**From:** Holly Duncan  
**Sent:** Monday, February 13, 2012 11:33 AM  
**To:** Jeff Watson  
**Subject:** RE: BL-11-00029 Leonard

**From:** Jeff Watson  
**Sent:** Tuesday, February 07, 2012 9:22 AM  
**To:** Christina Wollman; Brenda Larsen; Jan Ollivier; Holly Duncan  
**Subject:** BL-11-00029 Leonard

PROPOSED - Adjust Boundary to Creek

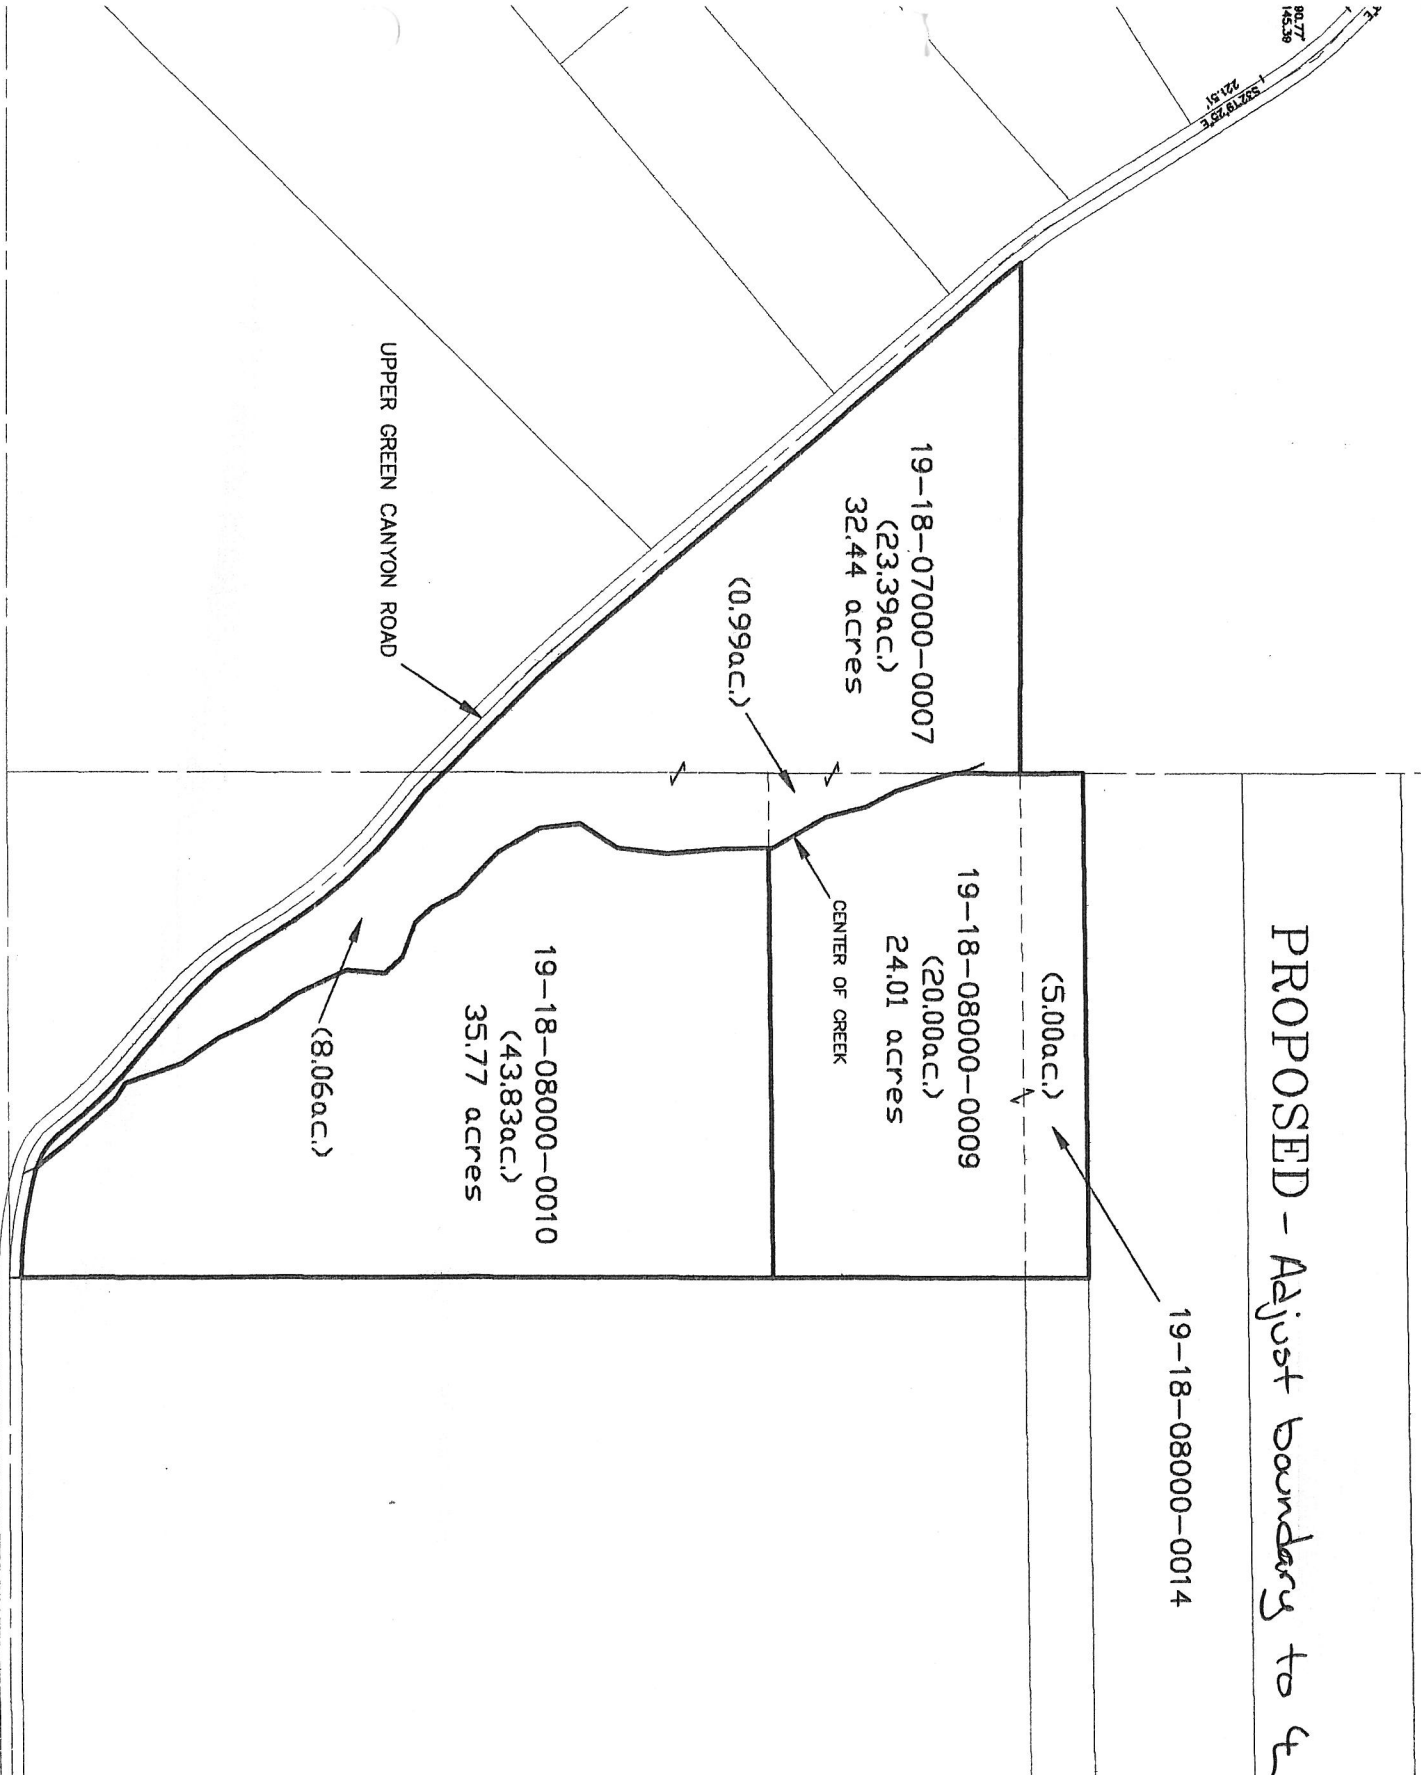
The applicant needs to be sure that proposed lines are not within 50 feet of existing wells and within 5 feet of drainfields.
